Ref - 4540-P03-A-Proposed Elevations and Section\_2017.01.16i

Windy Arbour, revised elevation / openings and light levels

4540 - P03 - A

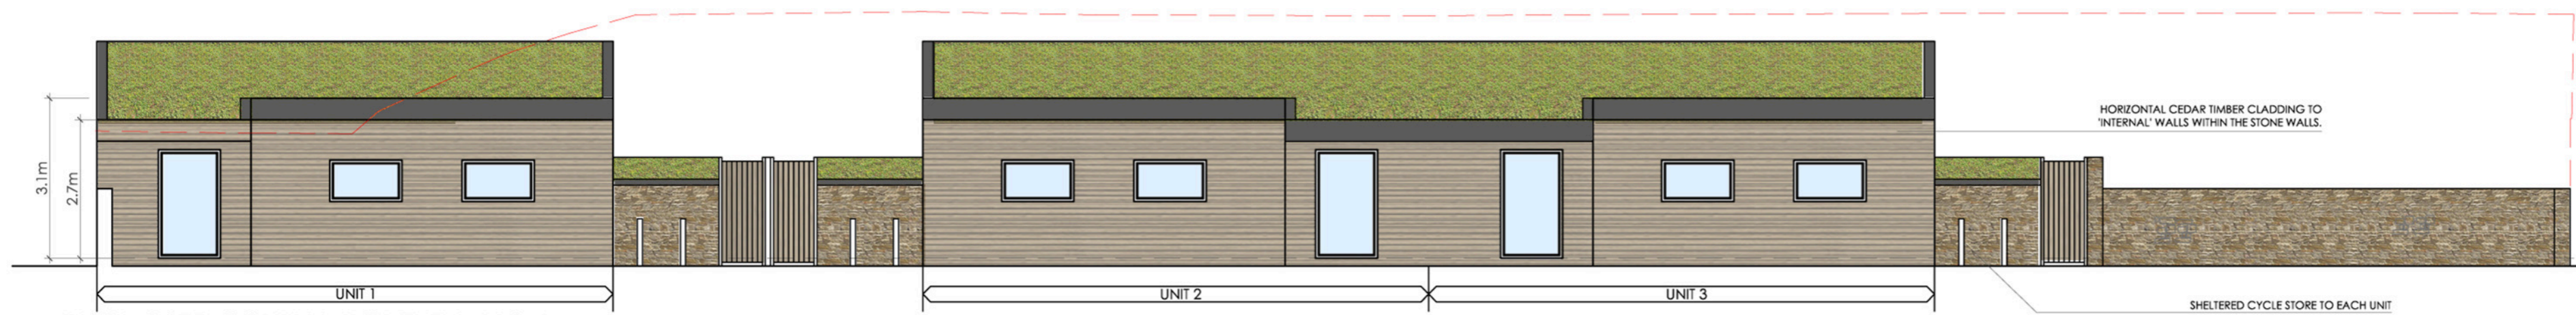
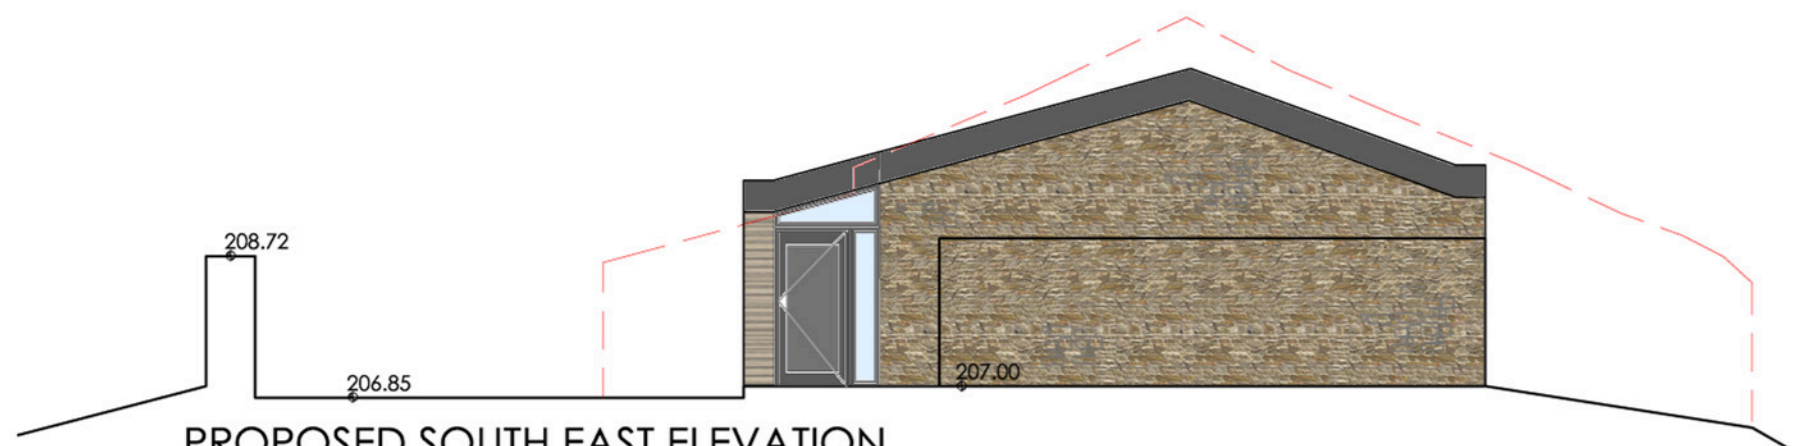
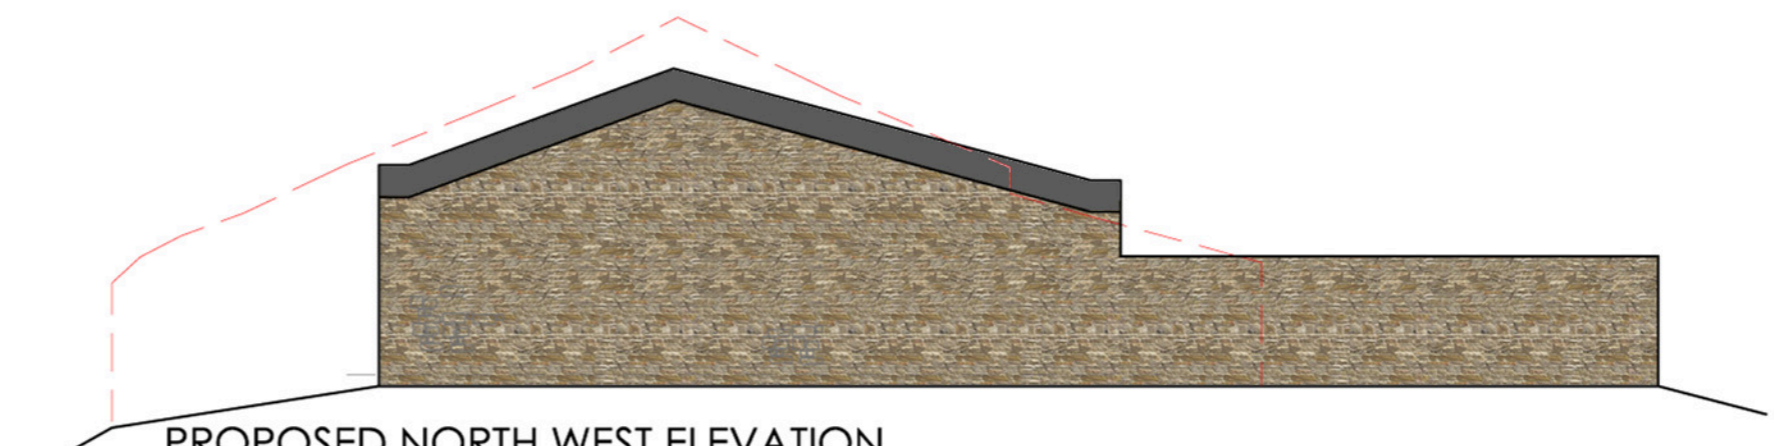
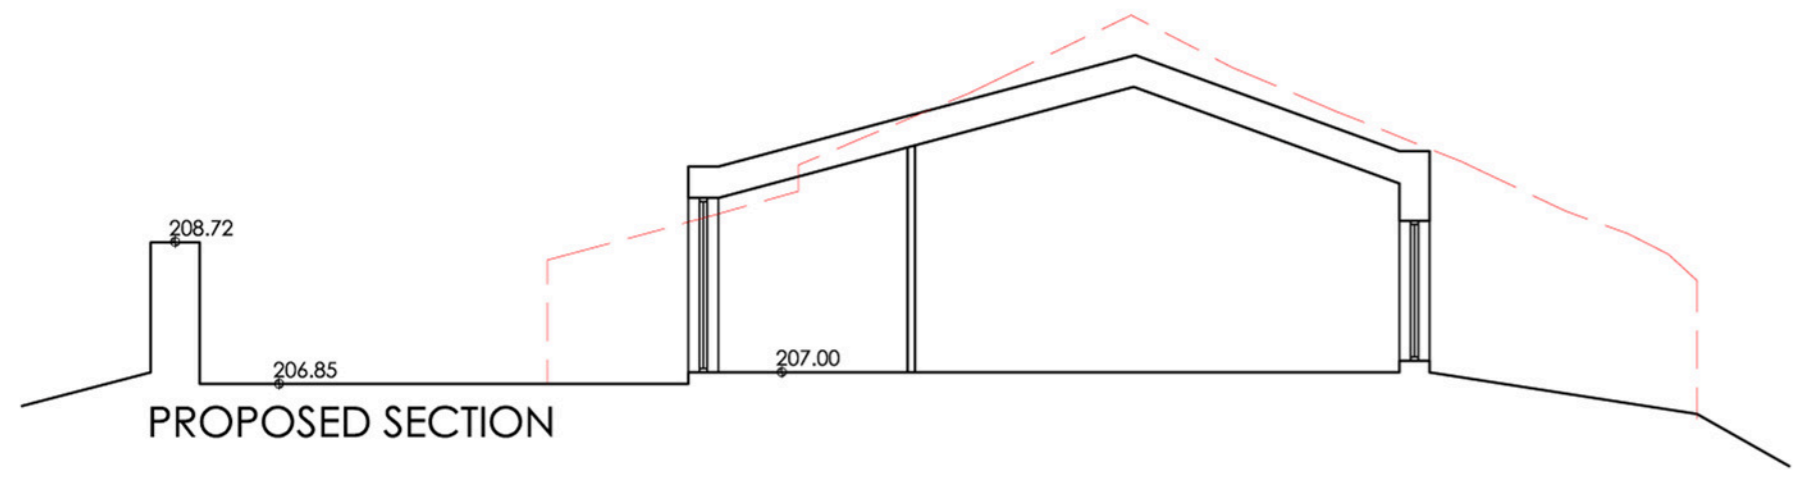
I have reviewed the revised elevations referenced above in the light of comments from Ribble Valley Borough Council / Forest of Bowland AONB and also with reference to our assessment of expected impacts in the document WindyArbourLVIA\_071016.

The removal of the continuous glazed opening below the eaves will significantly reduce emitted light levels. The remaining openings will be more typical of existing openings in the dwelling to the East of the development. We are of the opinion that the remaining openings will not make a significant impact upon the nocturnal character of the AONB landscape. This is aided by the presence of the existing dwelling with a number of openings both to the North East and East and the orientation of the proposed development towards the North East. The landscape to the North East is largely devoid of dwellings which have views of the site nor does it contain either distant or transient receptor points which have a views of the site.
